Application for a non-material amendment following a grant of planning permission.
 Town and Country Planning Act 1990

PA19/08429

- FULL HEIGHT FIXED DOUBLE GLAZED WINDOW ABOVE TRIPLE BI-FOLD DOORS
- ROOFLIGHT IN MASTER BEDROOM

2019-48-NMA-1.1

Triple bi-fold doors with
 fixed glazing above

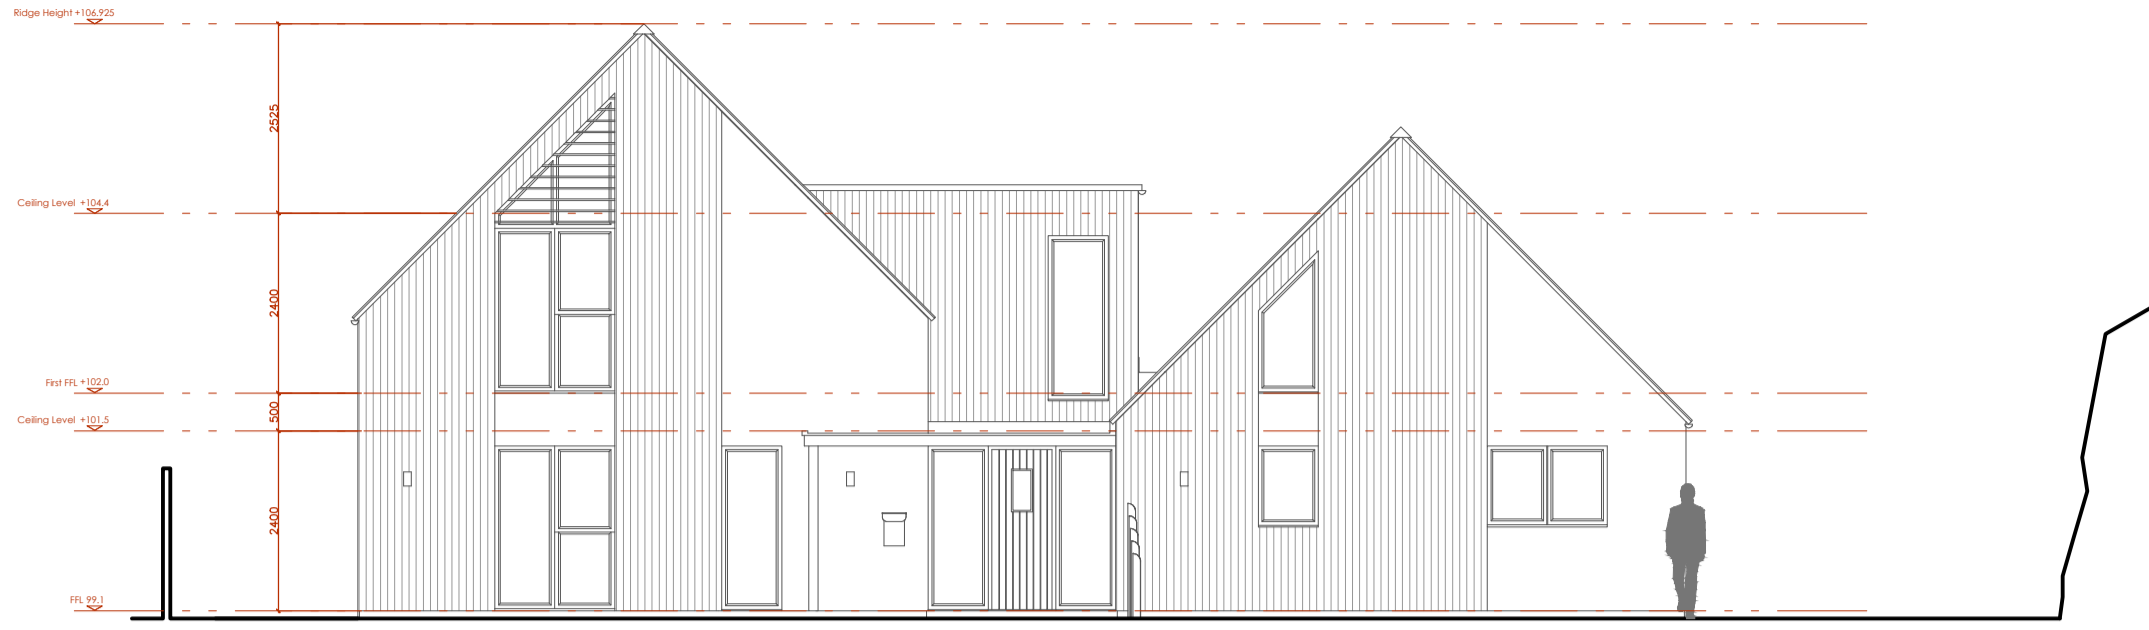
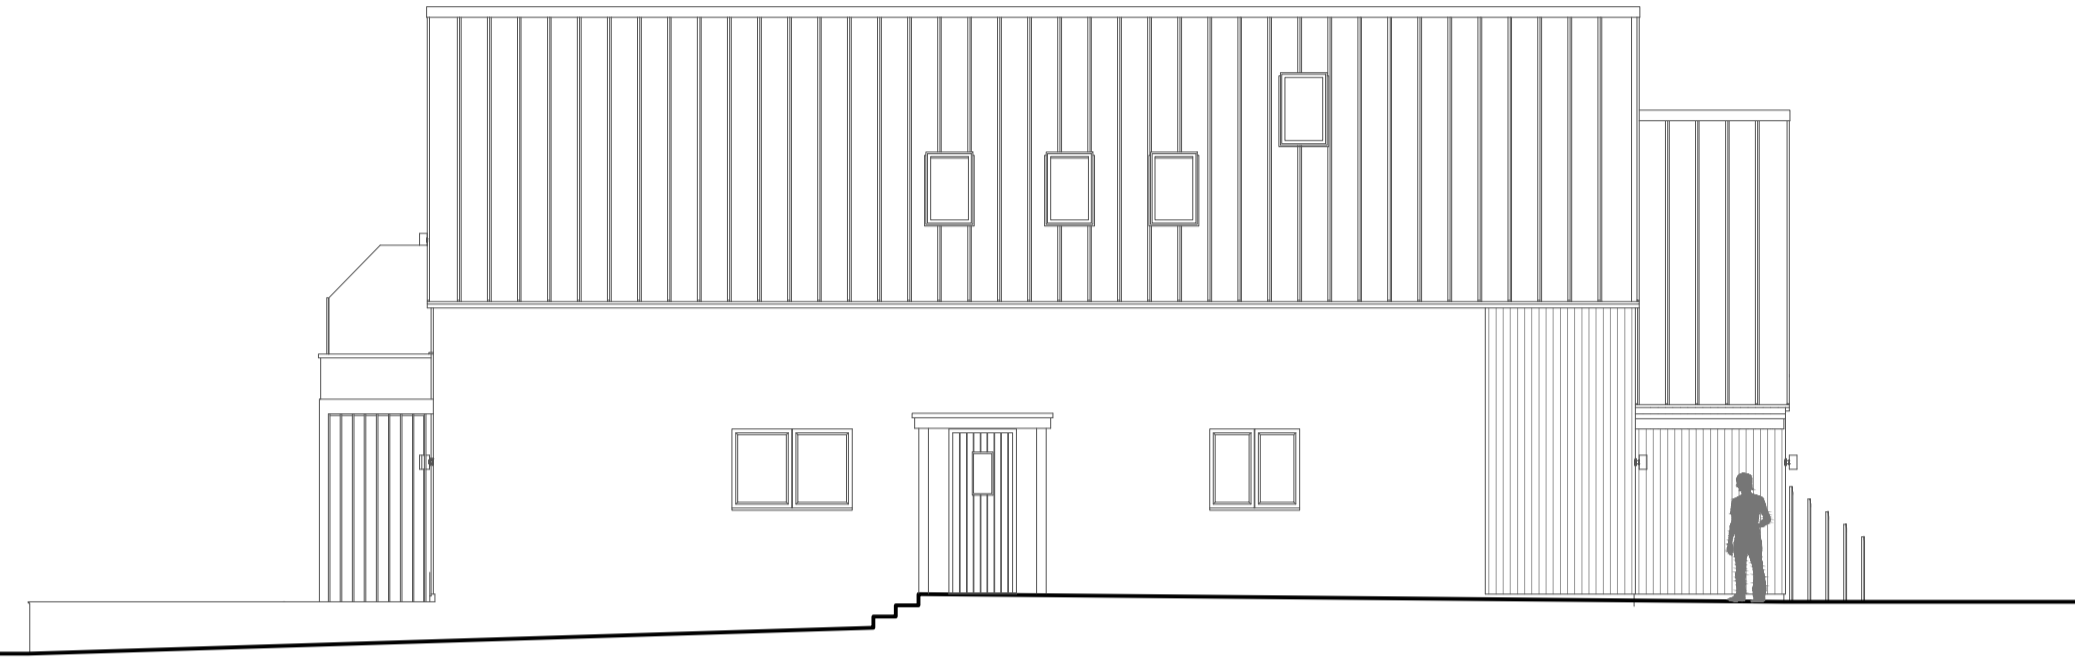
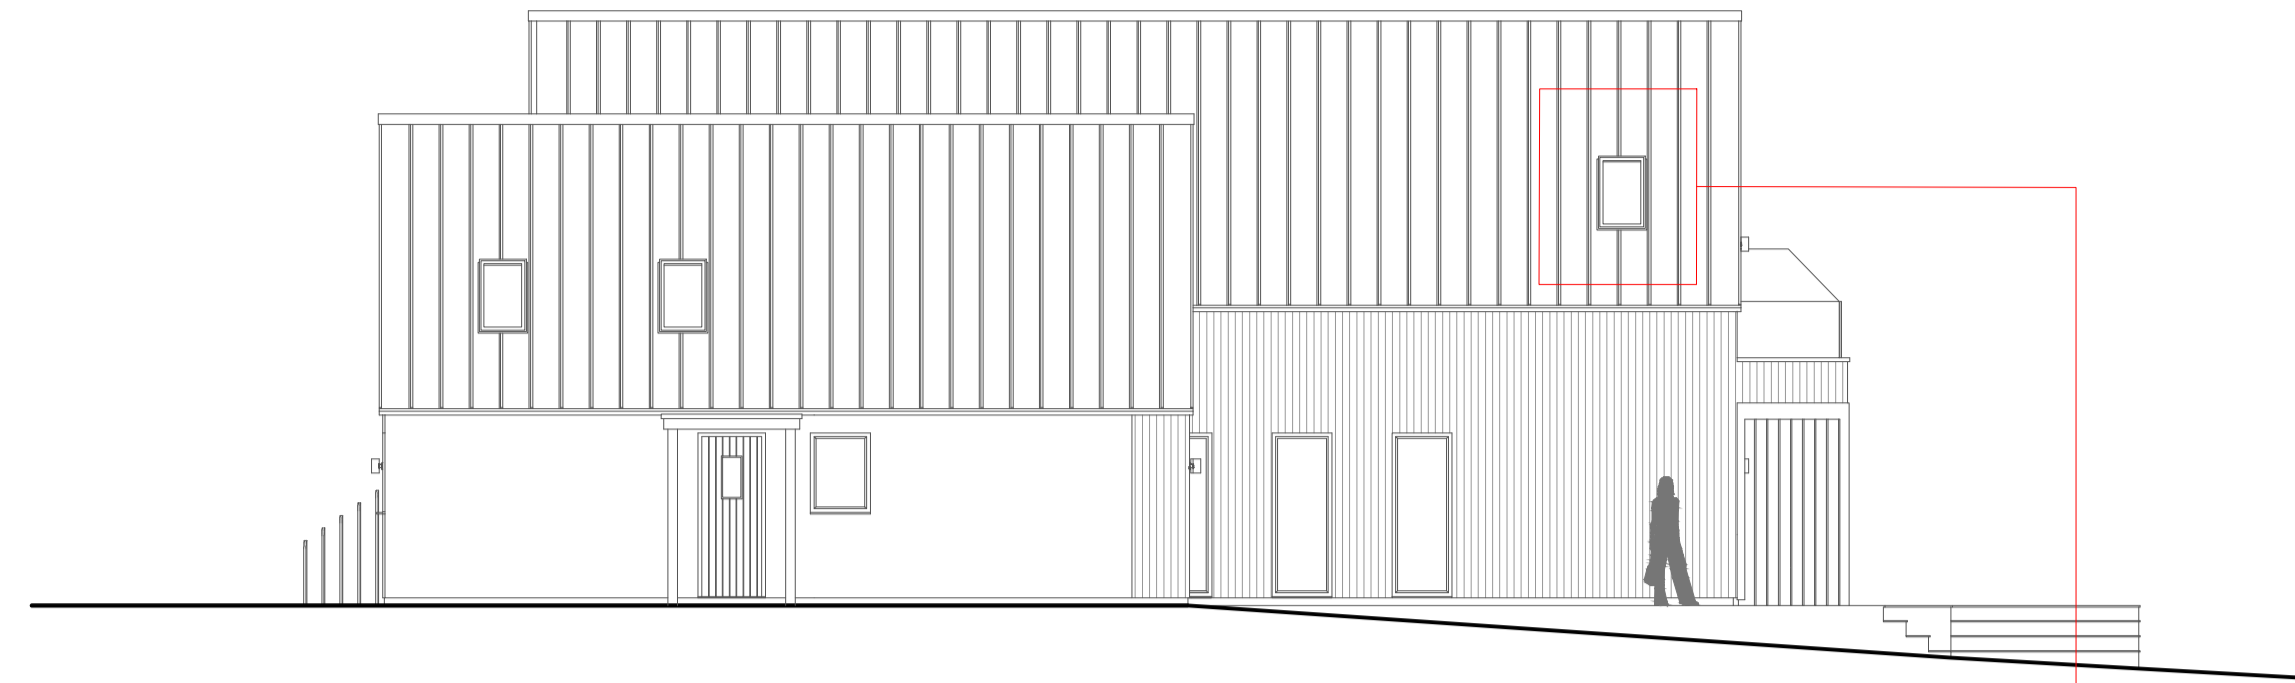
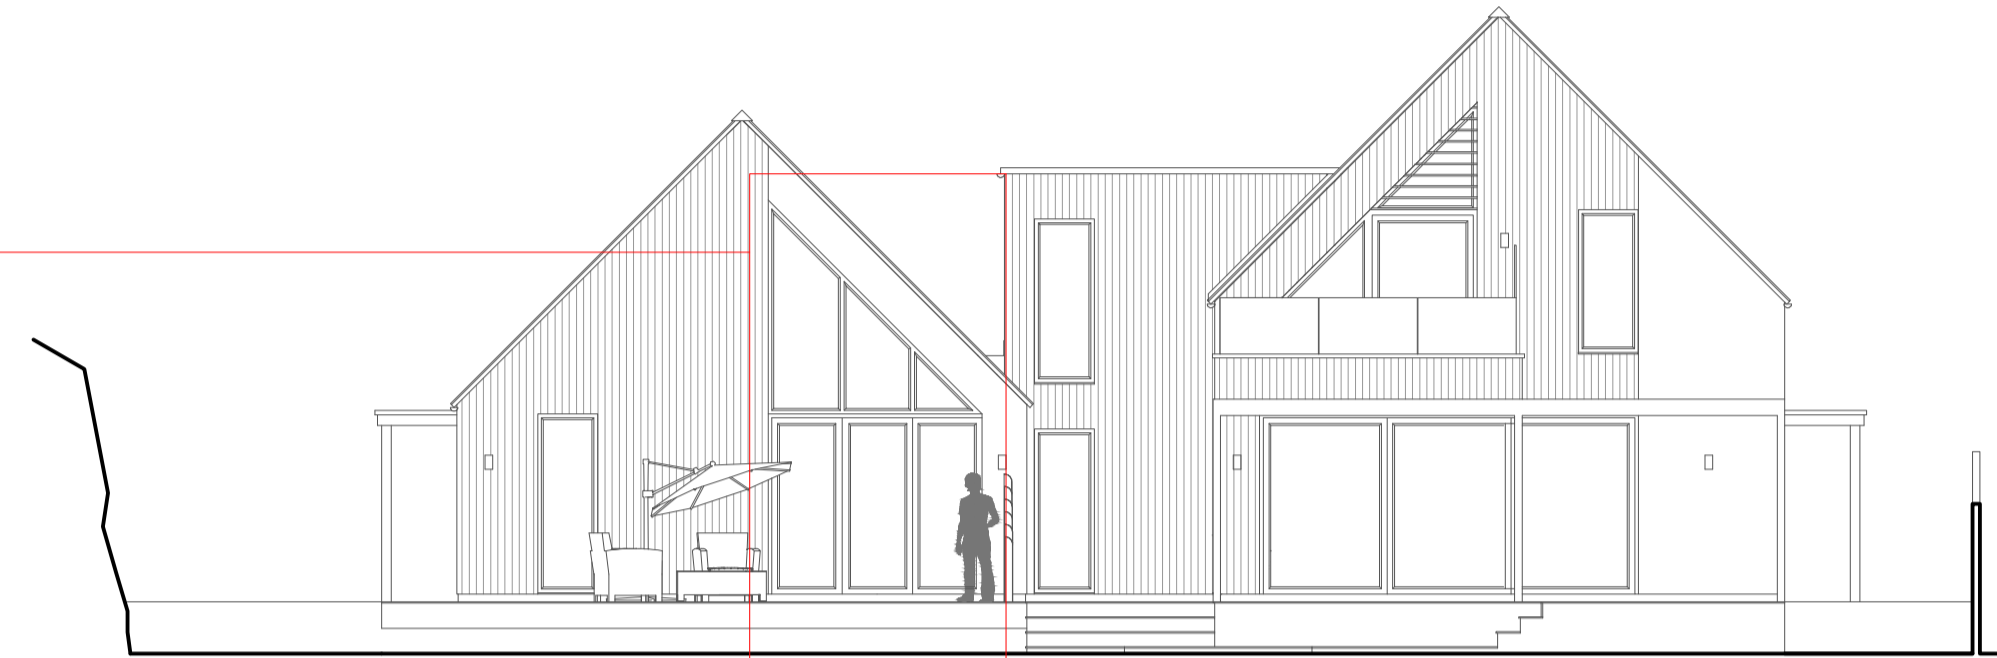
LIGHT/VIEWS FOR MEZZANINE AND DINING AREA
